**Re:** Planning Application 18/0837

**Address: Former Household Waste Recycling Centre off Whalley Road,  
LANGHO**

**Description: Development of the former waste recycling center to create four  
class B1/B8 business units.**

Drawing Title  
**Proposed Site Plan and Longsight Road**

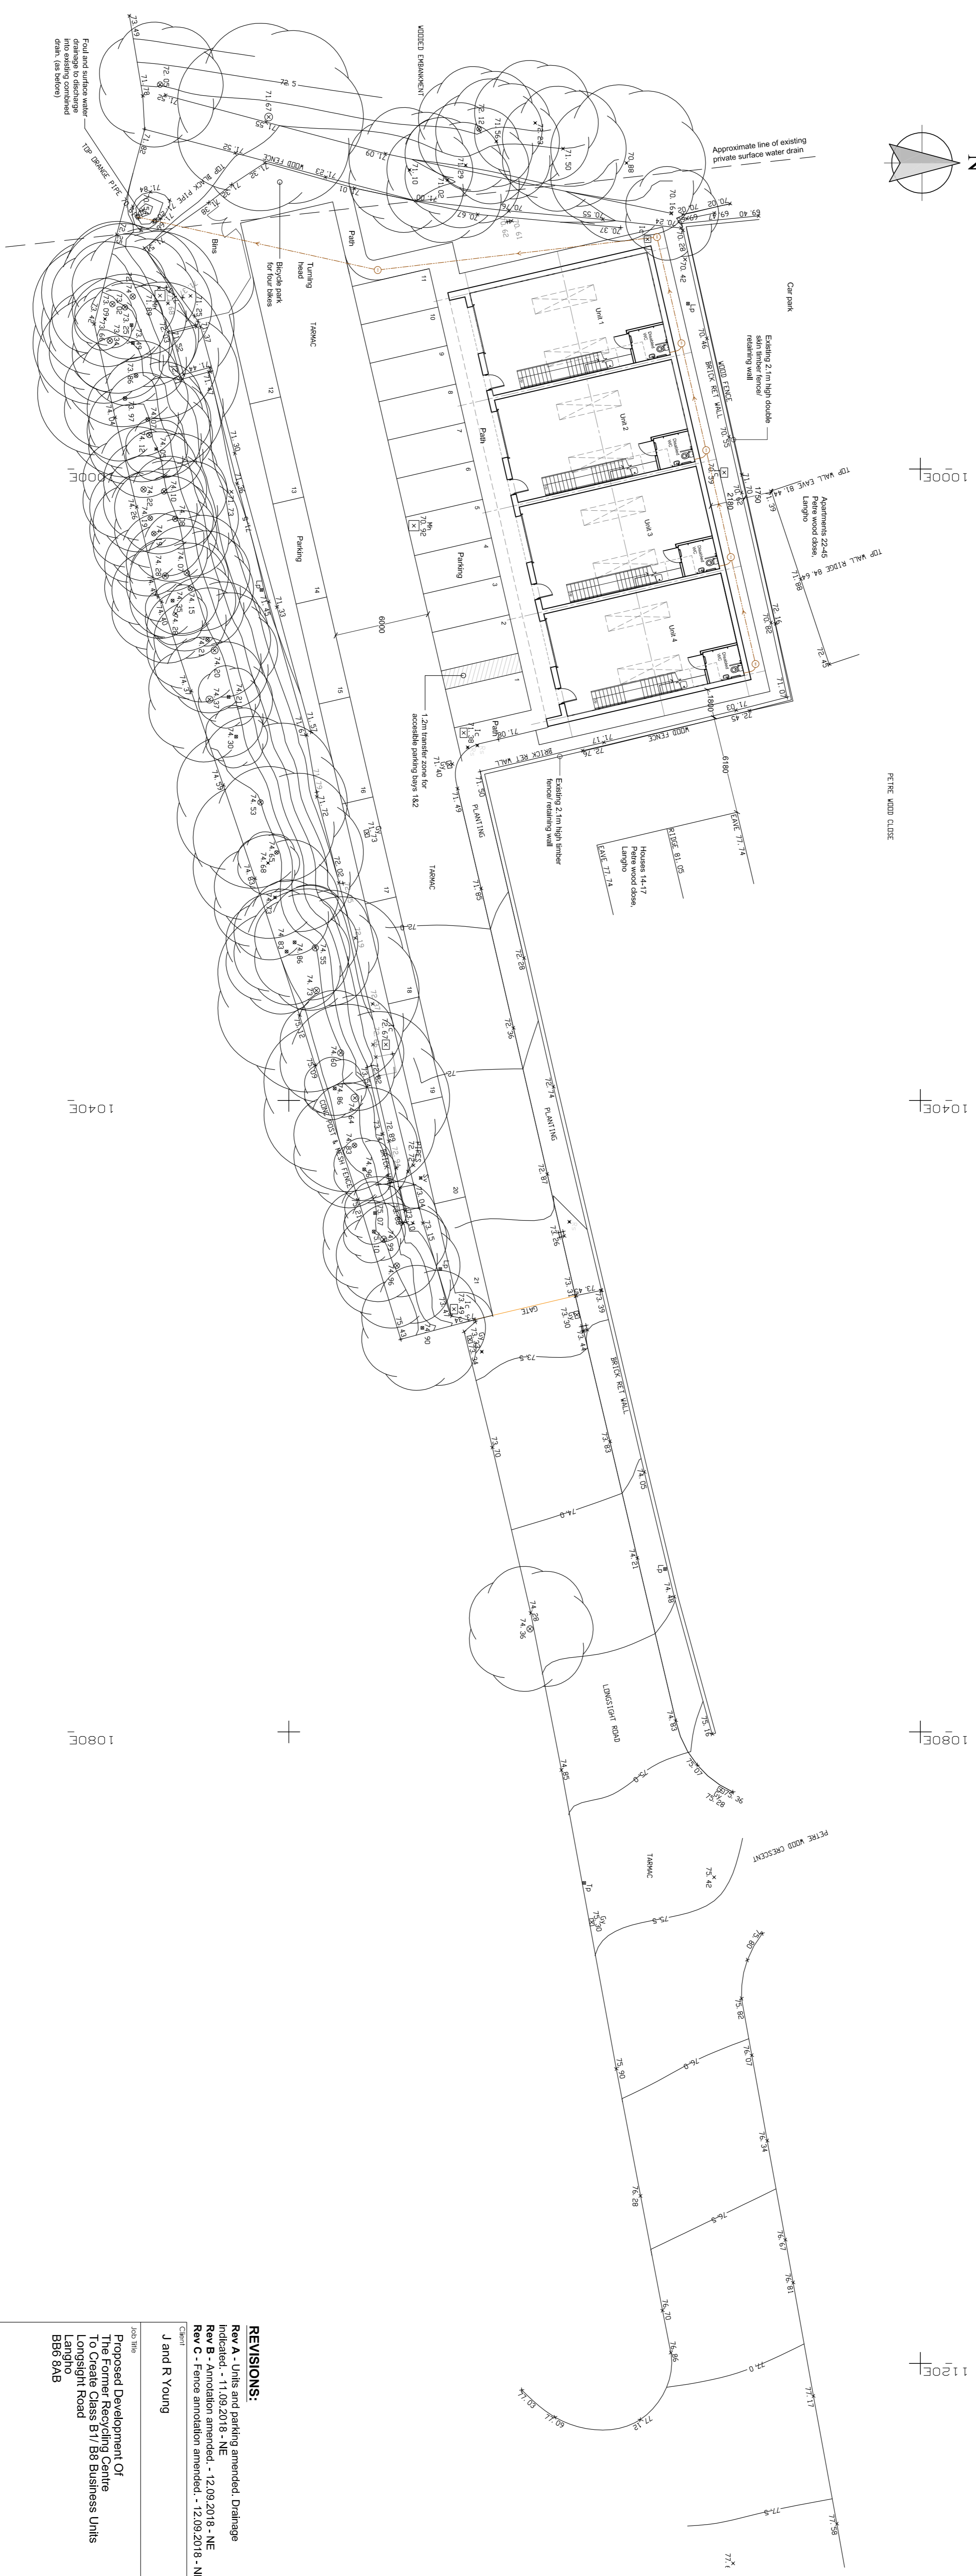
- The lack of pedestrian footways within the site, whilst Longsight Road has a footway to the gated access, the footway does not continue within the site. Additionally there is no pedestrian access onto the site.
- A swept path analysis should be provided showing how a refuse collection vehicle or large emergency vehicle such as a Fire Engine can enter and leave the site in a forward gear.
- There is no indication as to which direction the gates at the end of the adopted highway will open. Clause 153 of the 1980 Highways Act restricts the opening of gates and doors over the adopted highway; as such the gates must not open onto the adopted highway for perpetuity of the approval.

1. A turning head is required to allow refuse vehicle and emergency vehicles to turn within the site

2. All gates and associated mechanisms to be located outside the adopted highway and the gates to have physical restraints to prevent the gates from opening onto the adopted highway. **Reasons** to ensure the adopted highway is not obstructed by the gates or are a hazard to other road users.
